**PLANNING APPLICATION CONSULTATION RESPONSE**

<b>Application Number:</b>	3/2024/0451
<b>Proposal:</b>	Approval of details reserved by conditions 5 (SW drainage), 6 (Construction SW drainage plan) 10 (Construction Traffic Management Plan) and 13 (vehicular access) of planning permission 3/2023/0156.
<b>Location:</b>	Dog and Partridge Hesketh Lane Chipping PR3 2TH

**Lead Local Flood Authority Position**

HOME LIFE DEVELOPMENTS LTD
RESIDENTIAL REDEVELOPMENT
THE DOGS & PARTRIDGE
CHIPPING PRISTON
PROPOSED
DRAINAGE
LAYOUT
Date: 13/01/2024
Scale: 1/200

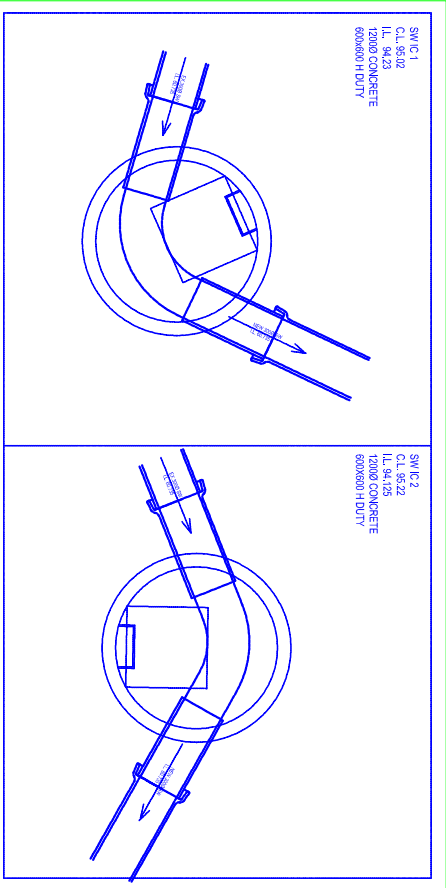
- The applicant as failed to provide evidence of an urban creep allowance applied to the development, as specified in the wording of the condition.
- The applicant has failed to provide a drainage layout that clearly identifies the specific surface water manholes, at present these are all labelled as SW IC, therefore it is difficult to cross references these with the calculations.
- The applicant has failed to provide a sufficient flood water exceedance plan that demonstrates how surface water will convey throughout the site in the event of the

The applicant has stated on the drainage layout that the finished floor levels are TBC (to be confirmed), although the current proposals are acceptable in principle in relation to being set a minimum of 150mm above the adjacent ground levels and covers levels, should there be any possibility that these might be reduced, the Lead Local Flood Authority expects this information to be finalised at this time before a recommendation for discharge of the final detailed drainage design condition to be confirmed.

EXISTING
SIV EXCEEDANCE ROUTES
LAYOUT

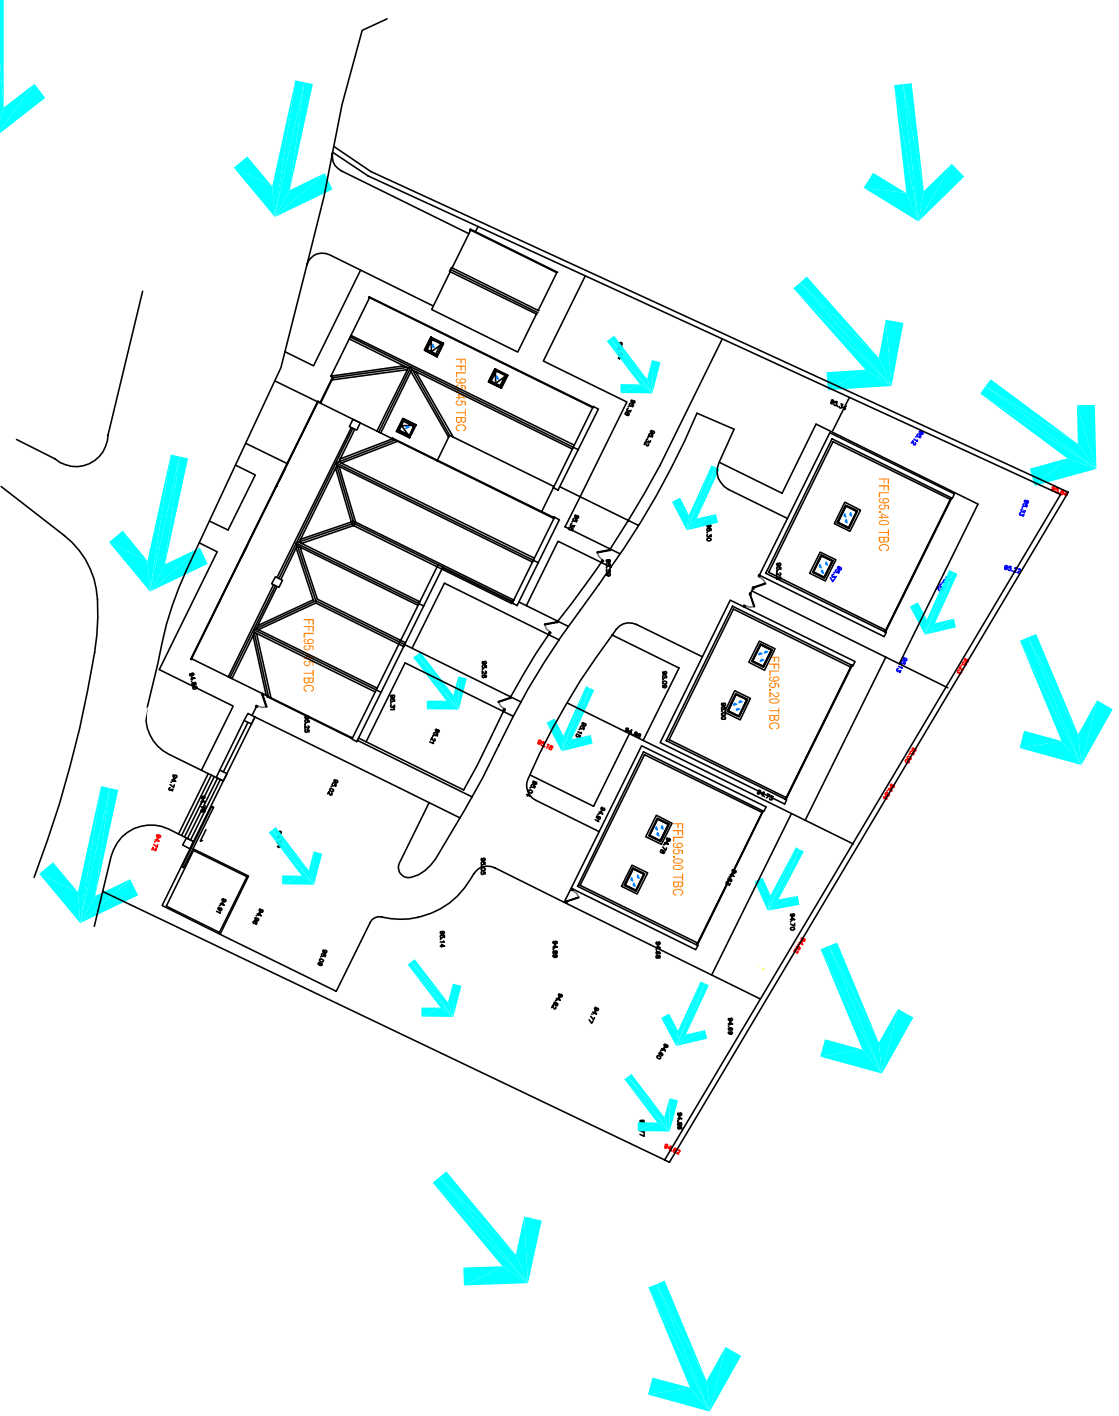
surface water drainage system flooding. The applicant should provide a flood exceedance route plan that corresponds with the proposed surface water drainage layout for the development.
